CSP SCAREBROOK
PROJECT NO. 20171683945
PUBLIC RECORD PARCEL NO. 6118009003
CROWN CASTLE SITE ID: 823520
CROWN CASTLE SITE NAME: CS GOODMAN AND SONS
17997 SIERRA WAY
MONUMENT, COLORADO 80132
EL PASO COUNTY
EXISTING 68'-0" MONOPINE
(OVERALL HEIGHT: 73'-0" A.G.L.)
COLLOCATION COMMUNICATION SITE

SHEET TITLE: **TITLE SHEET**

Add PCD File No. TWR183

**OVERALL PARENT PARCEL
 SCALE 1" = 100'**

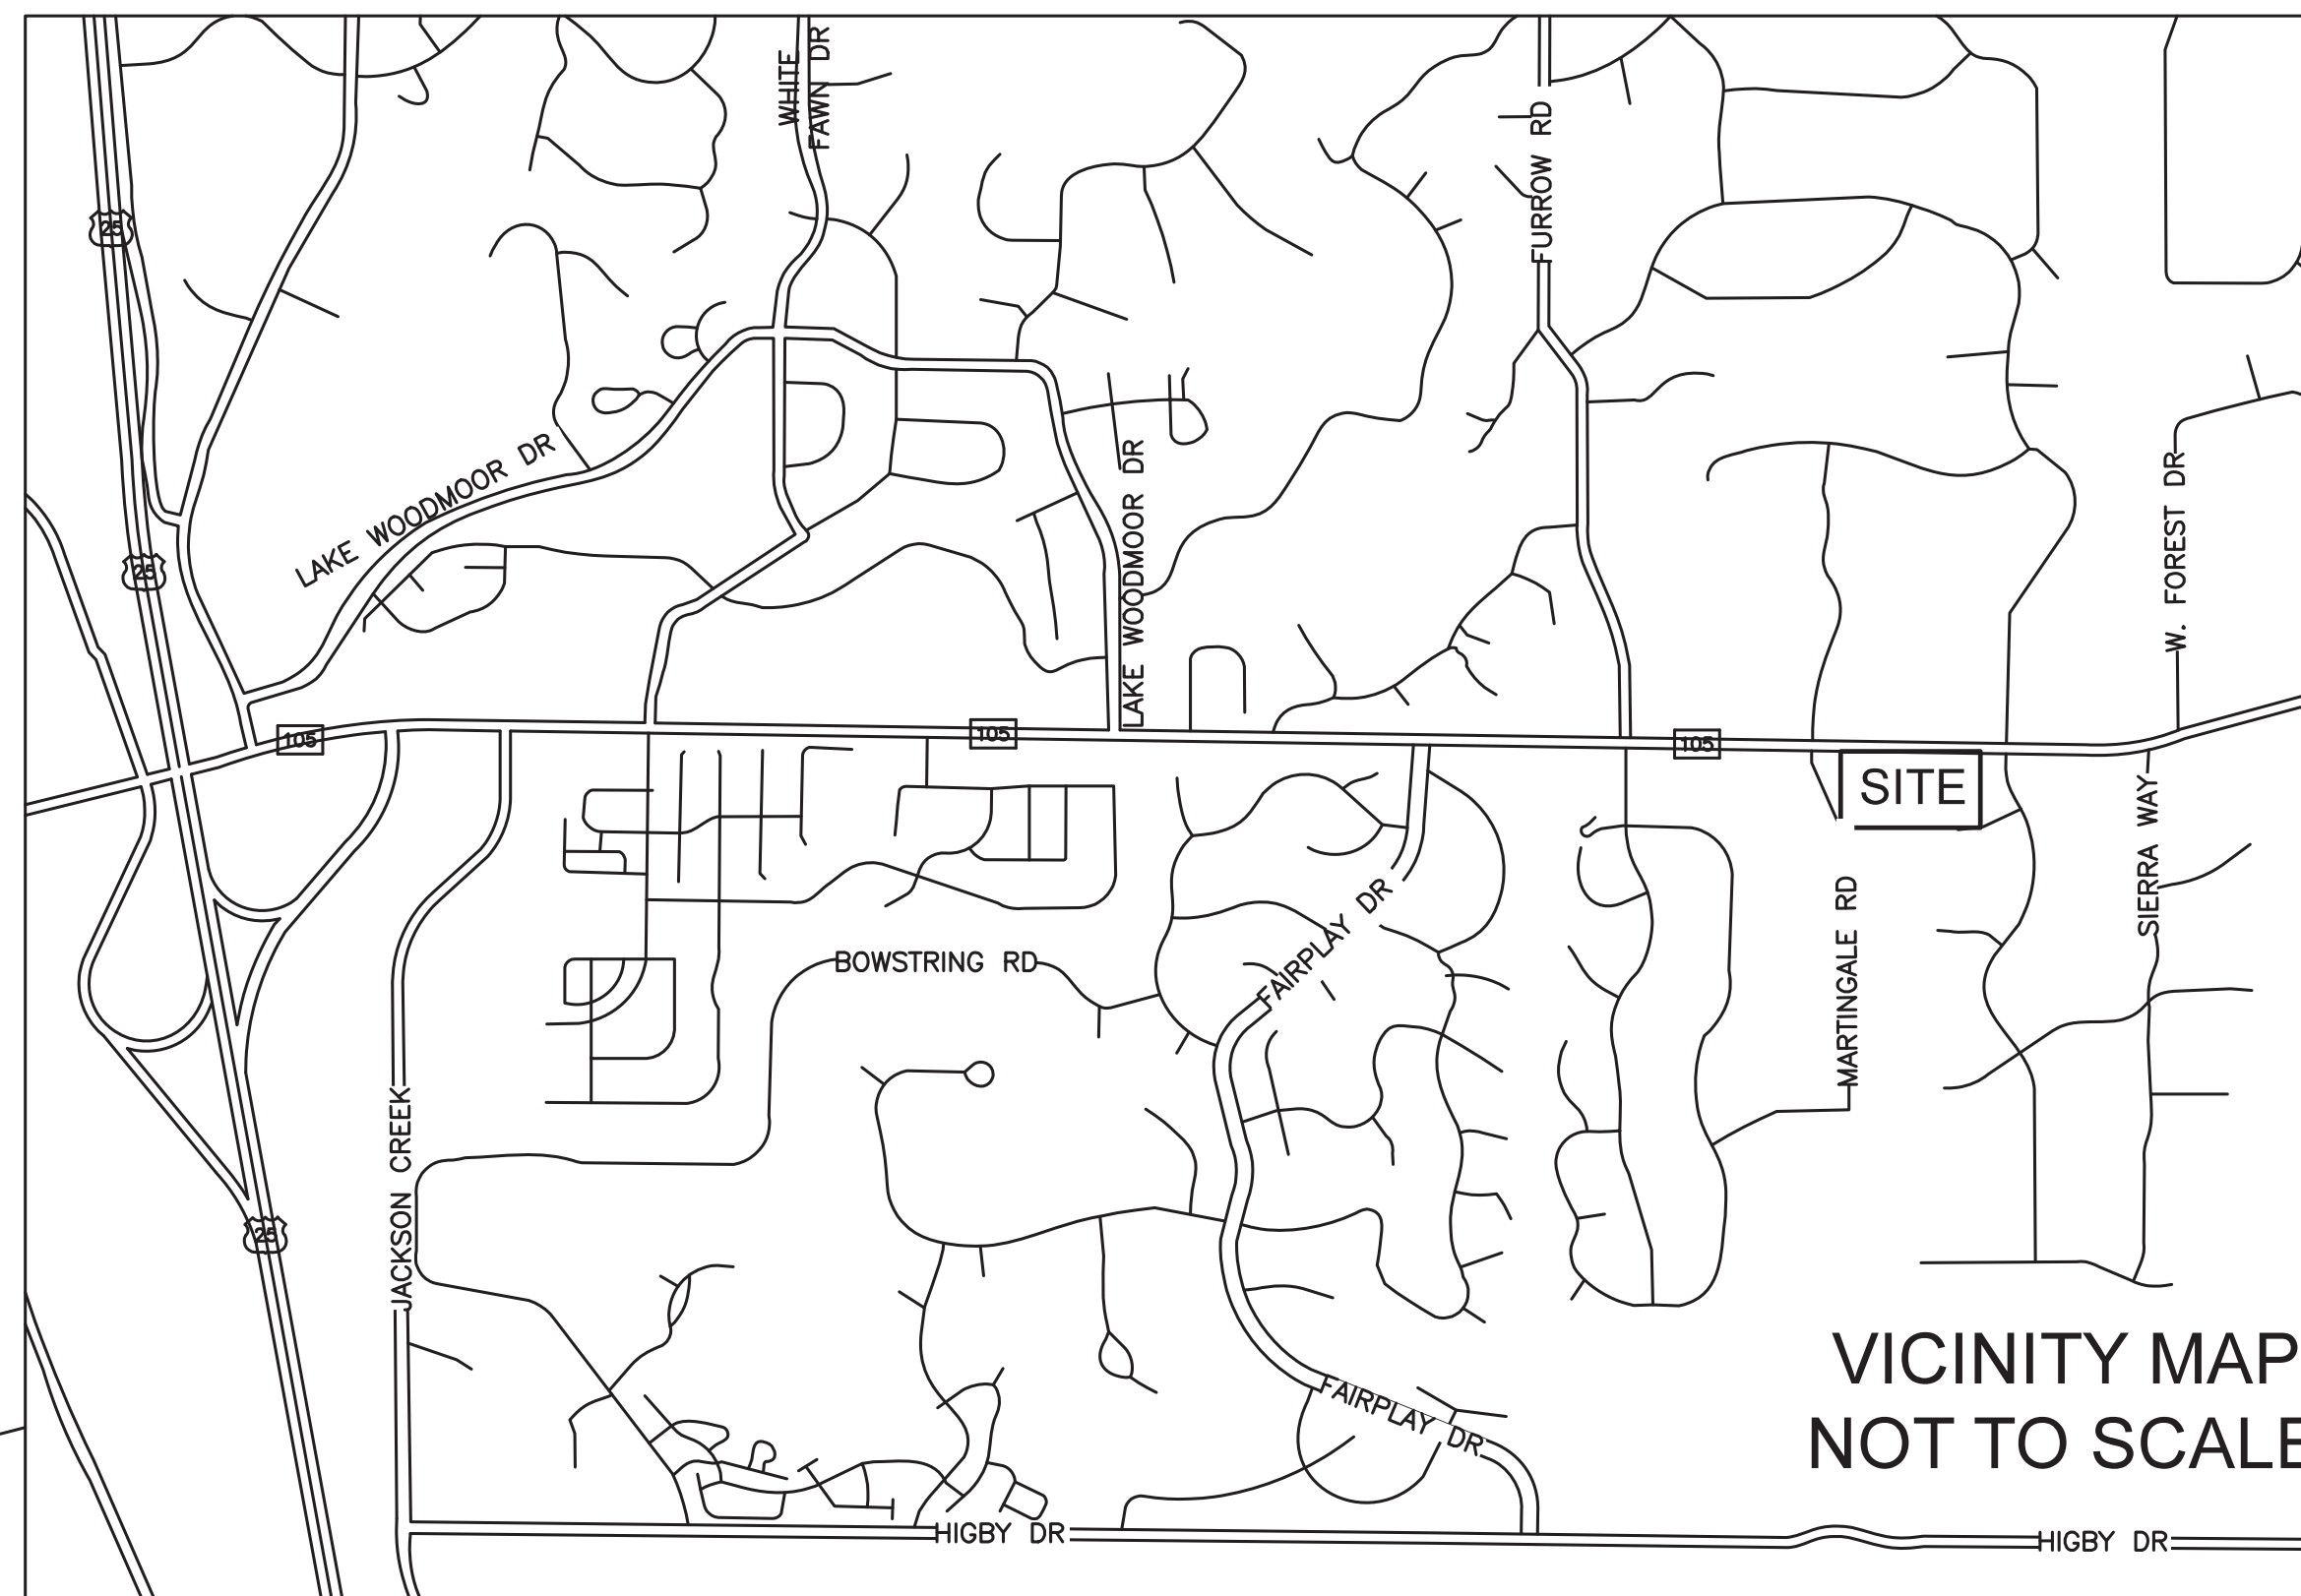
This is Highway 105.
 Update where applicable.

Show this access point
 as closed off.

mark this as the
 existing tower.

ACCESS EASEMENT
SCALE 1" = 30'

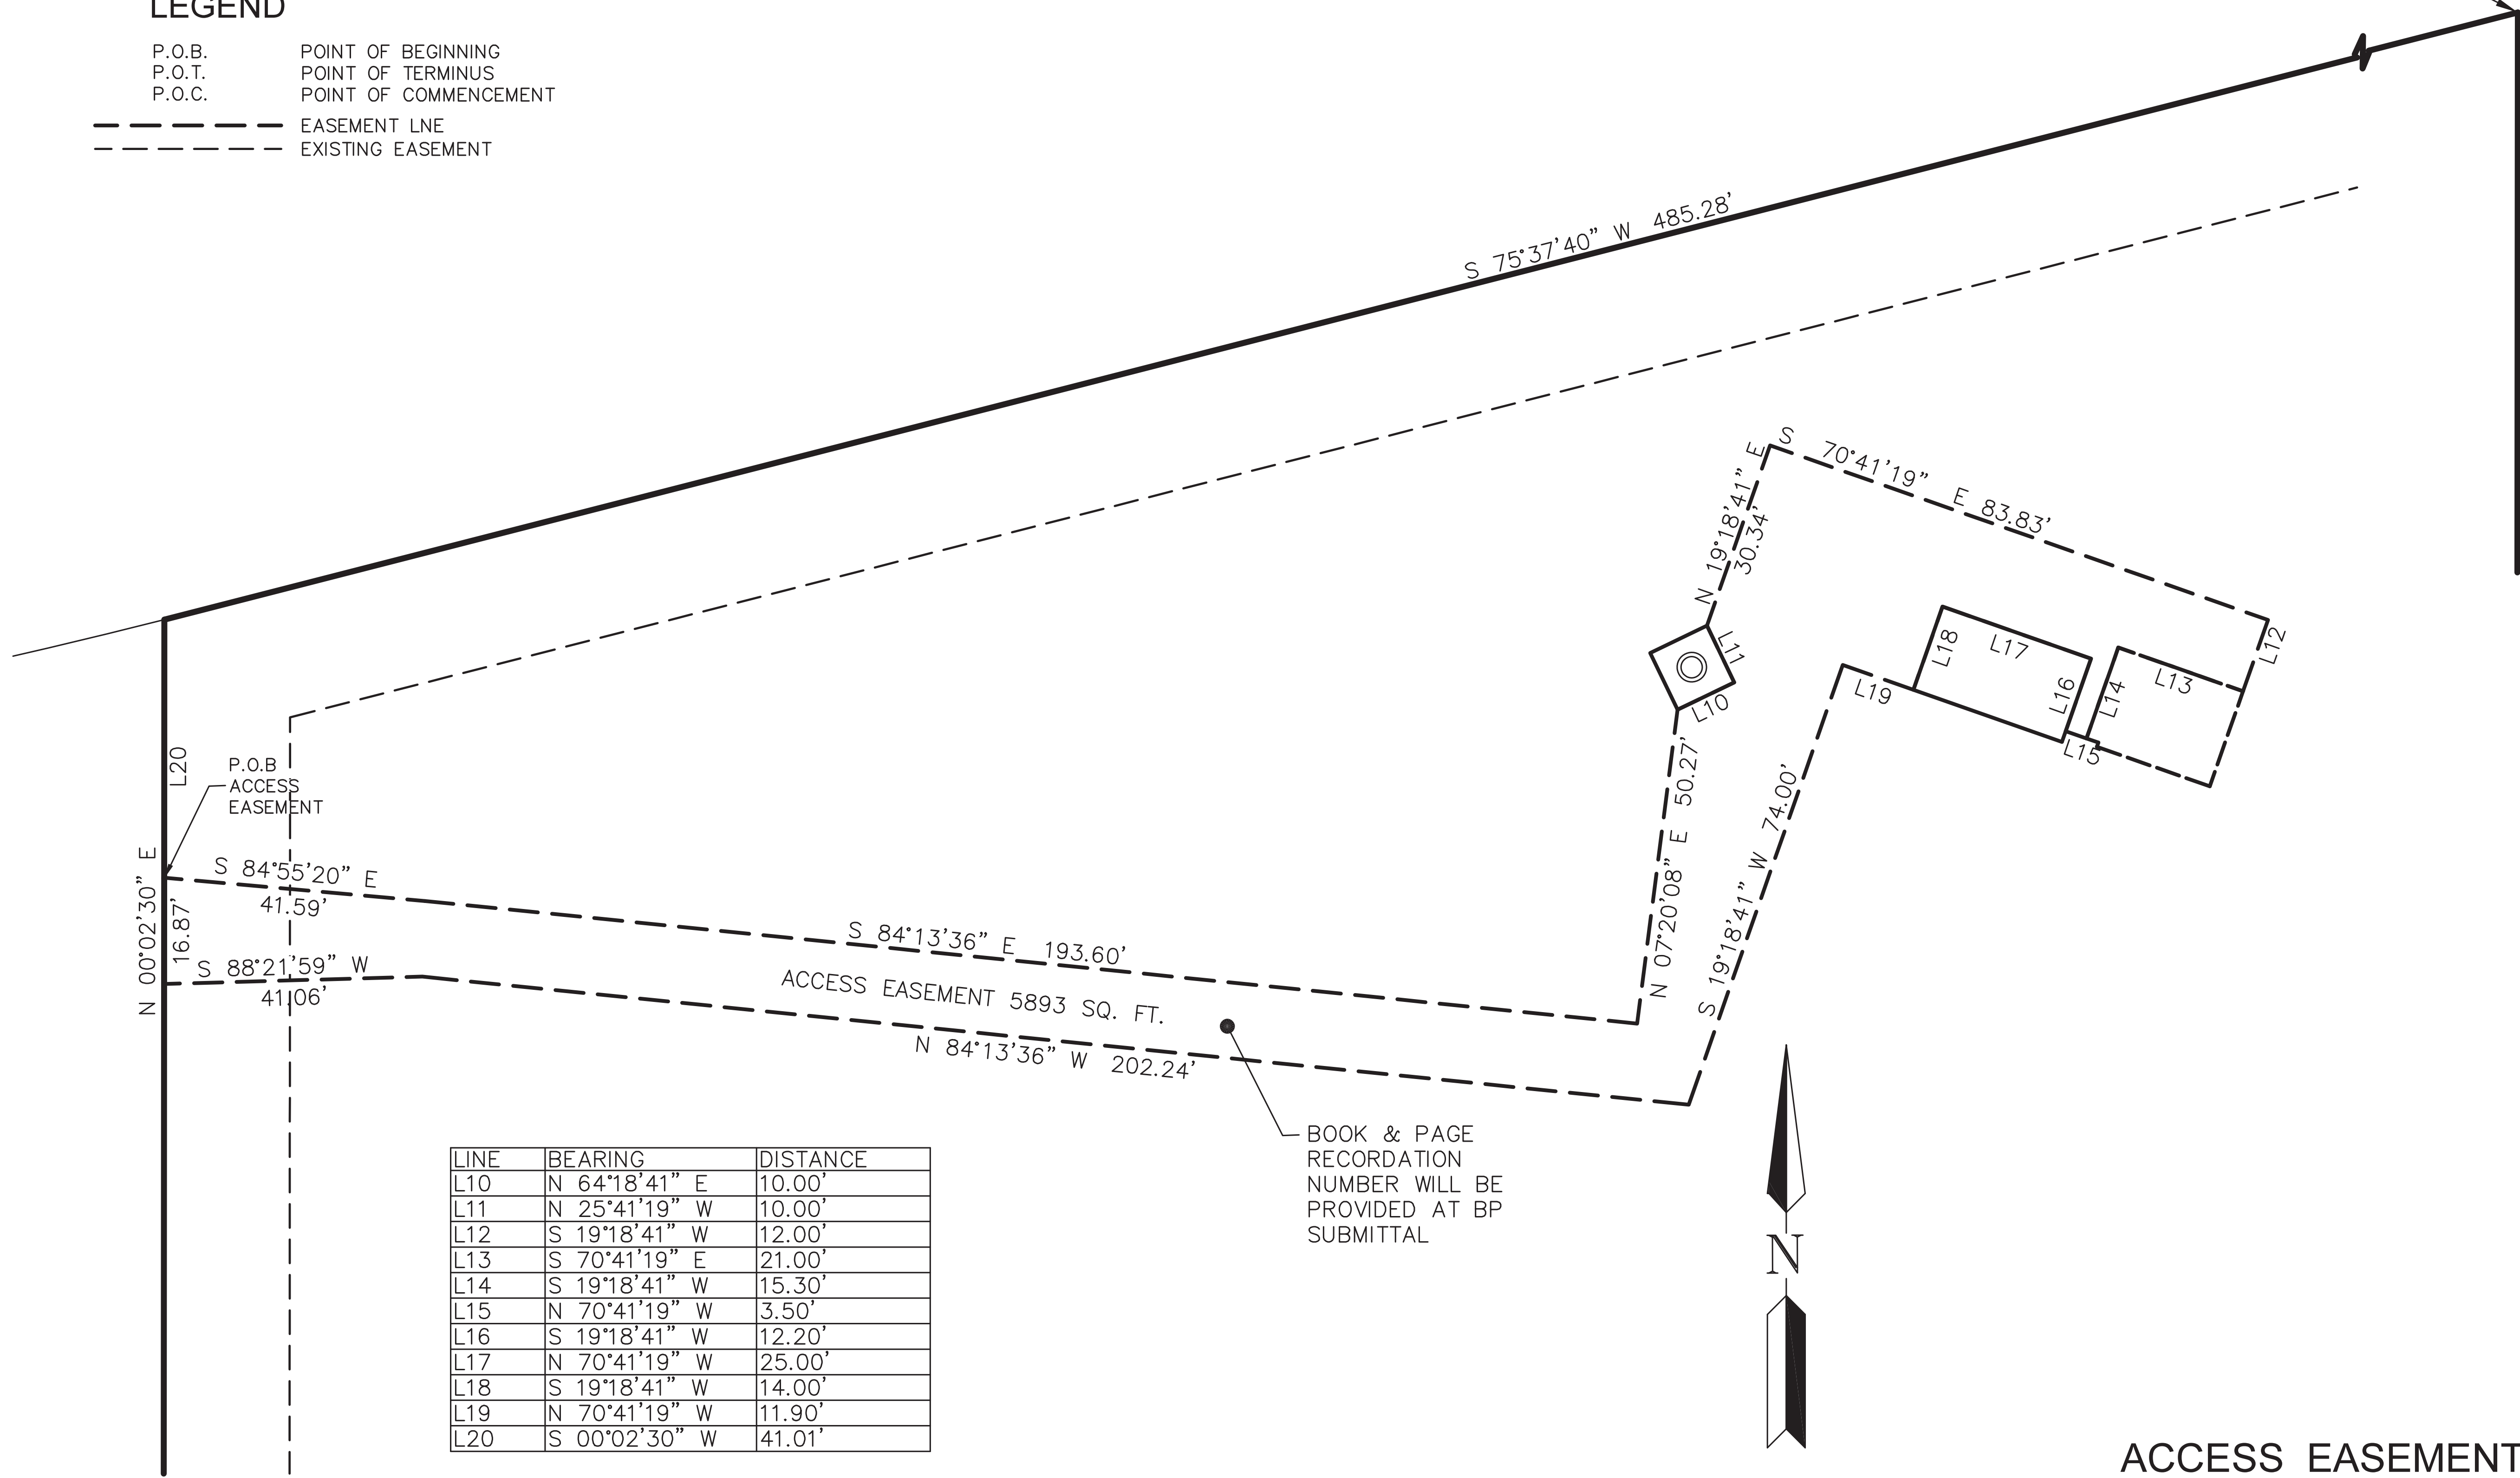
Provide the Book and Page or Recordation # for the access easement.
